Application by Highways England for an Order Granting Development Consent for A57 Link Roads

Deadline 4 - response on behalf of High Peak Borough Council

Responses from High Peak Borough Council are provided in red to outstanding matters discussed in the hearing session held during the week commencing 7th February 2022.

Drawing Number	HE551473 - BBA - EGN - A57_AL_SCHEME - DR - LE - 060414
Location	Location
Scale	1:5,000
Original Size	A3
Rev	P01

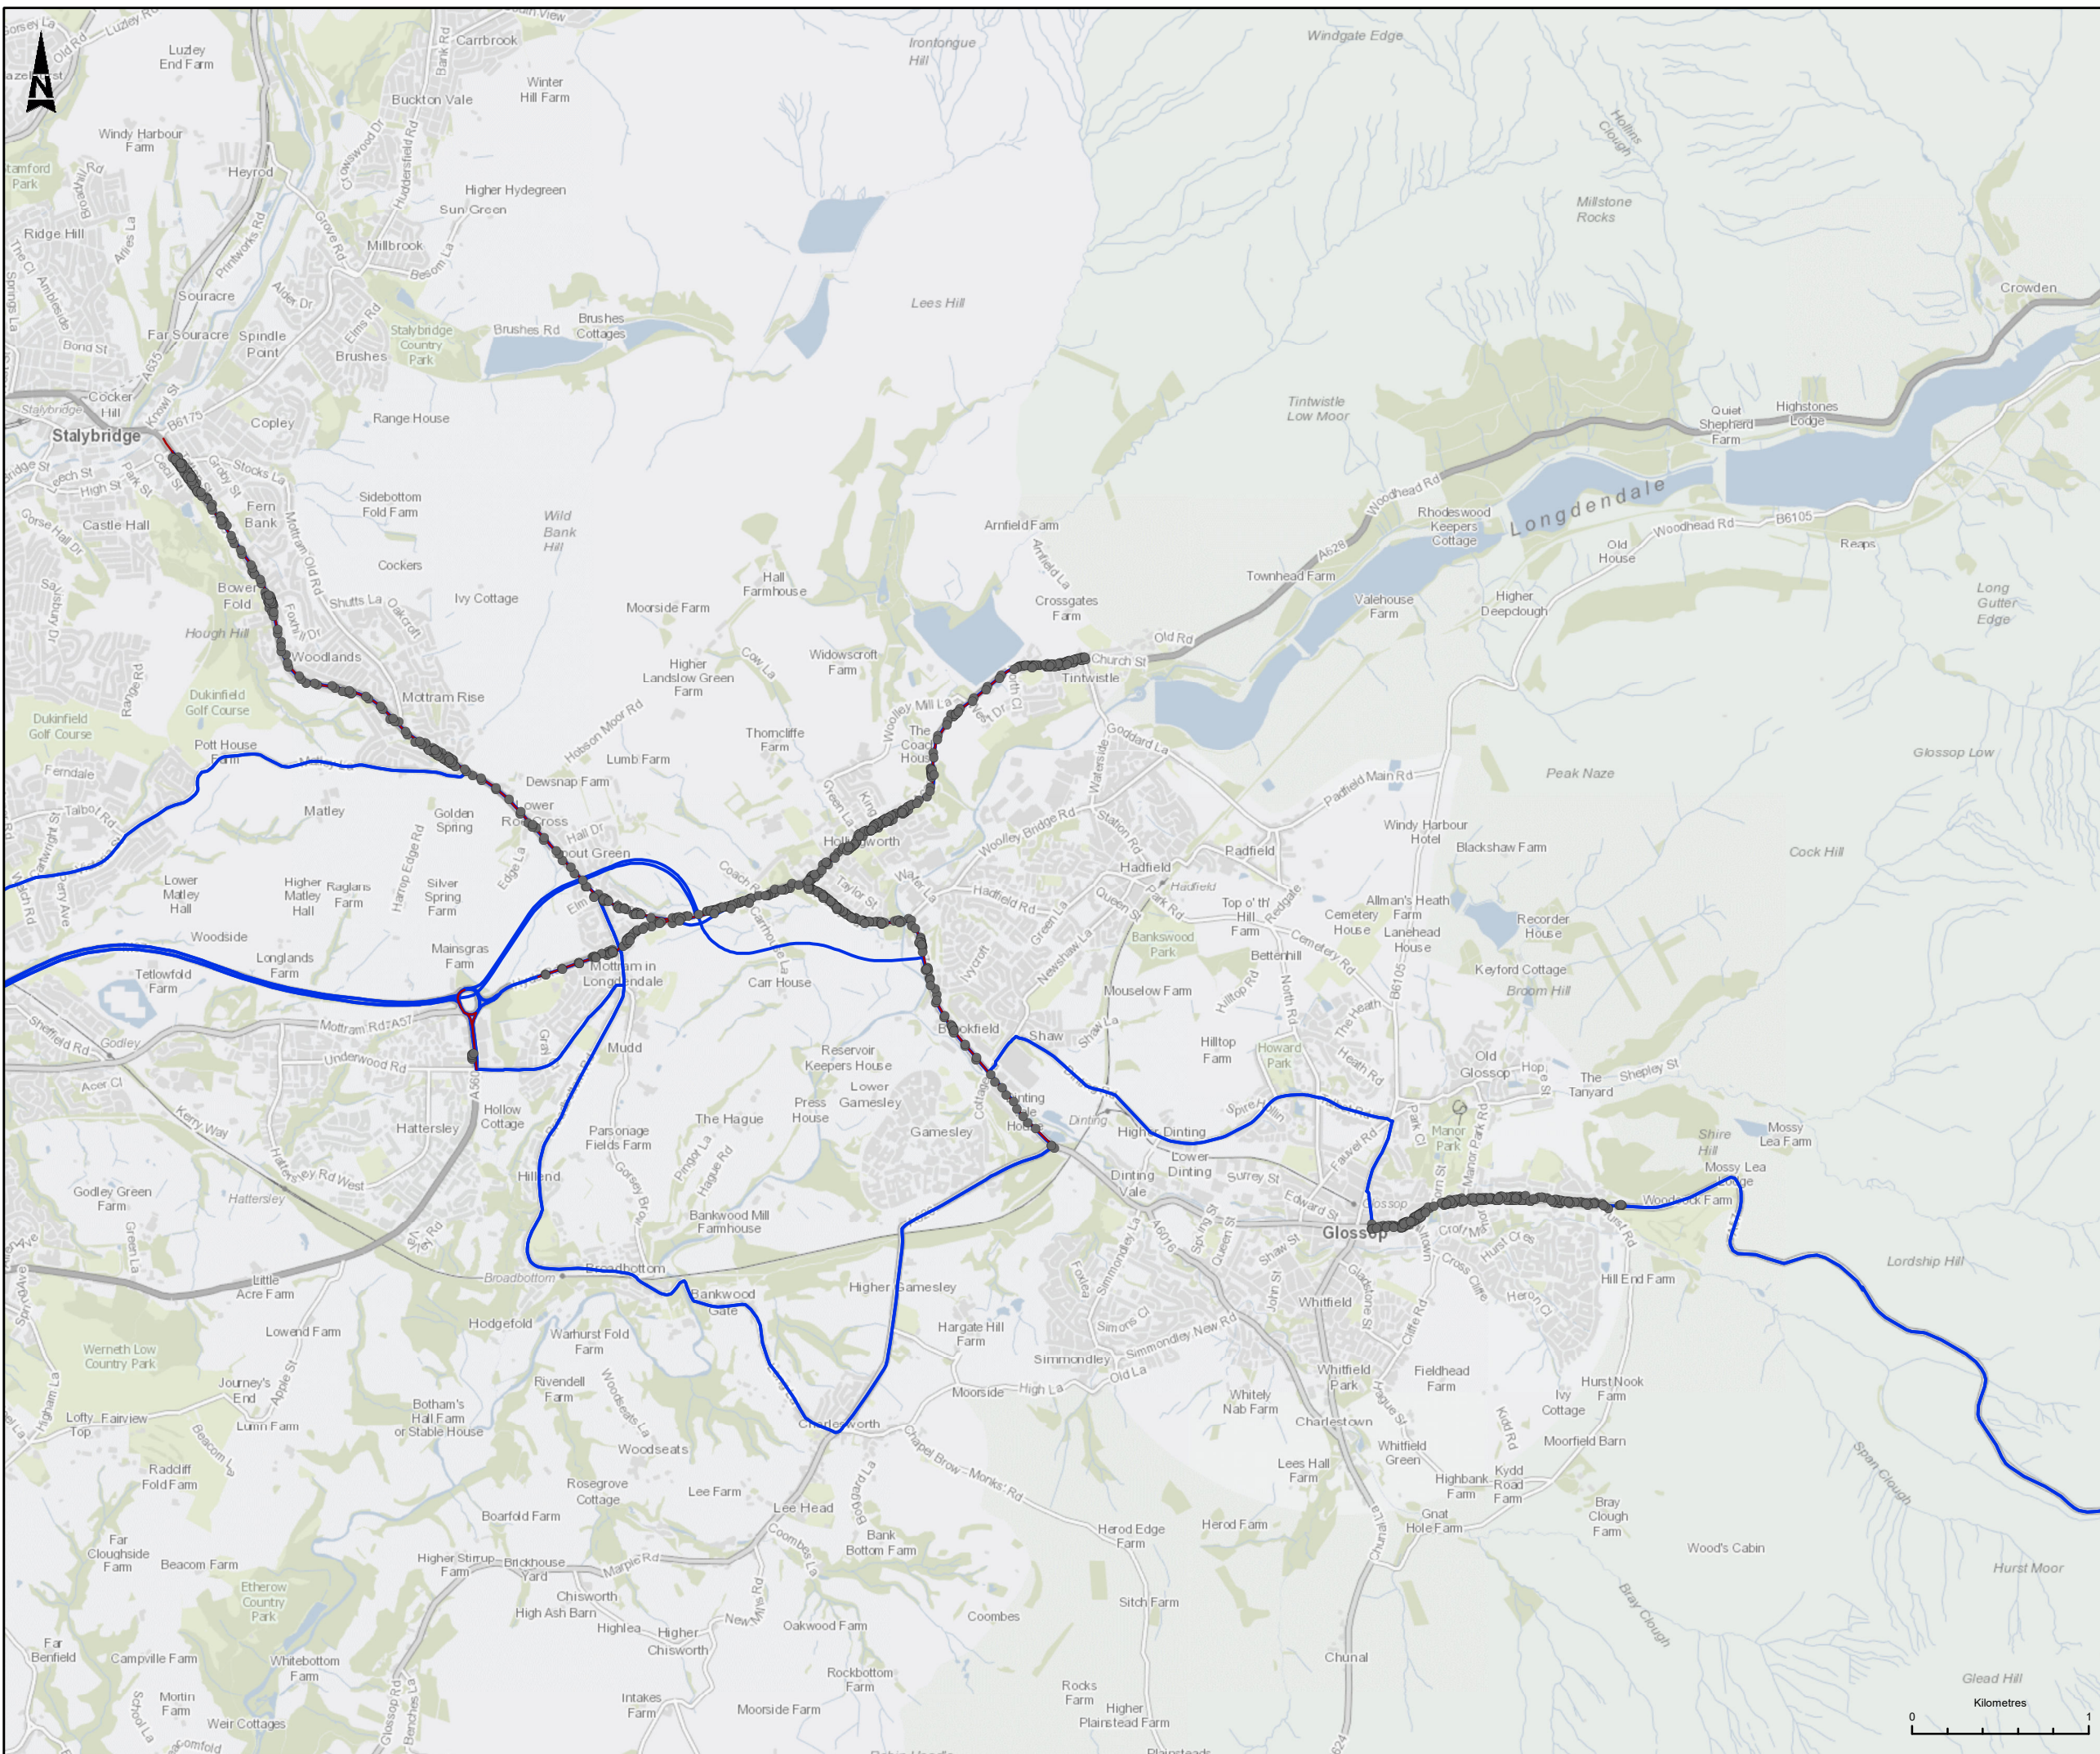
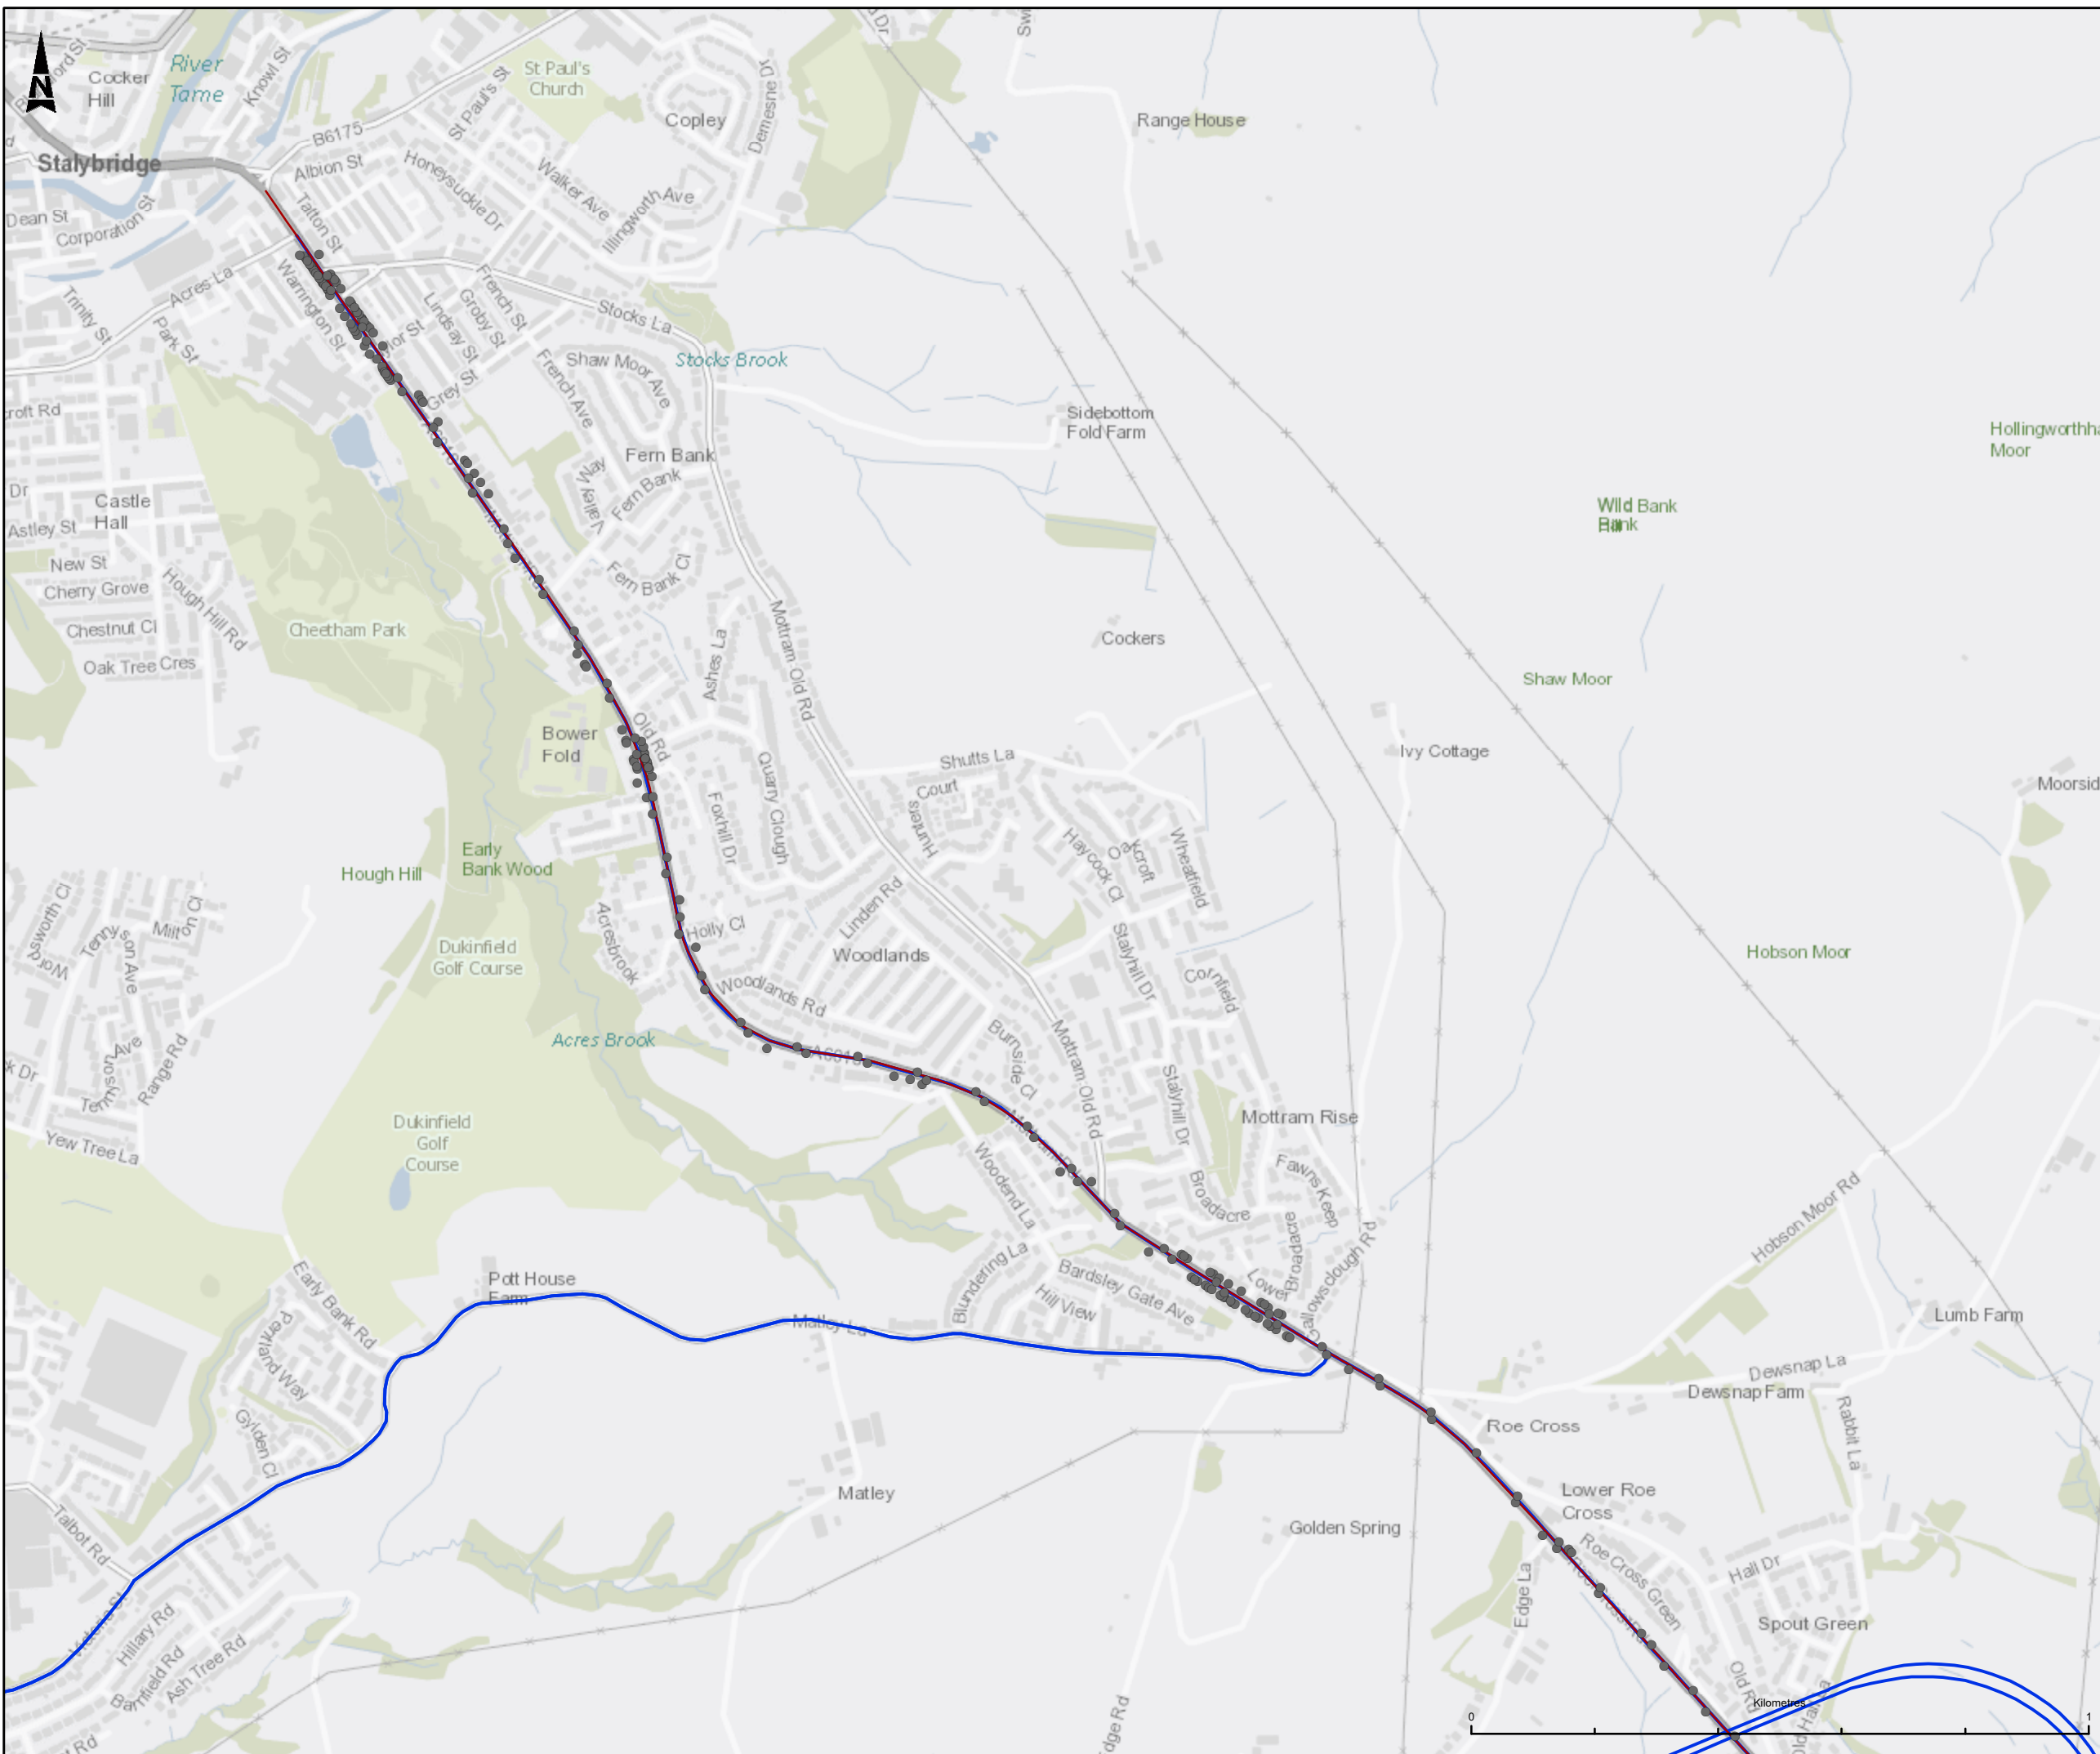
8.38 aa	Response is accepted with regards the details of dust control measures being set out in the EMP Nuisance Management Plan which will form an annex of the EMP (second iteration). The response however does not cover the second part of the issue, 'Qualifying features for the compliance assessment and receptors considered in the local air quality assessment along the A57 Brookfield are expected to show a large increase in NO2 concentrations in the opening year. The qualifying features for the compliance assessment are not labelled on Figure 5.4'
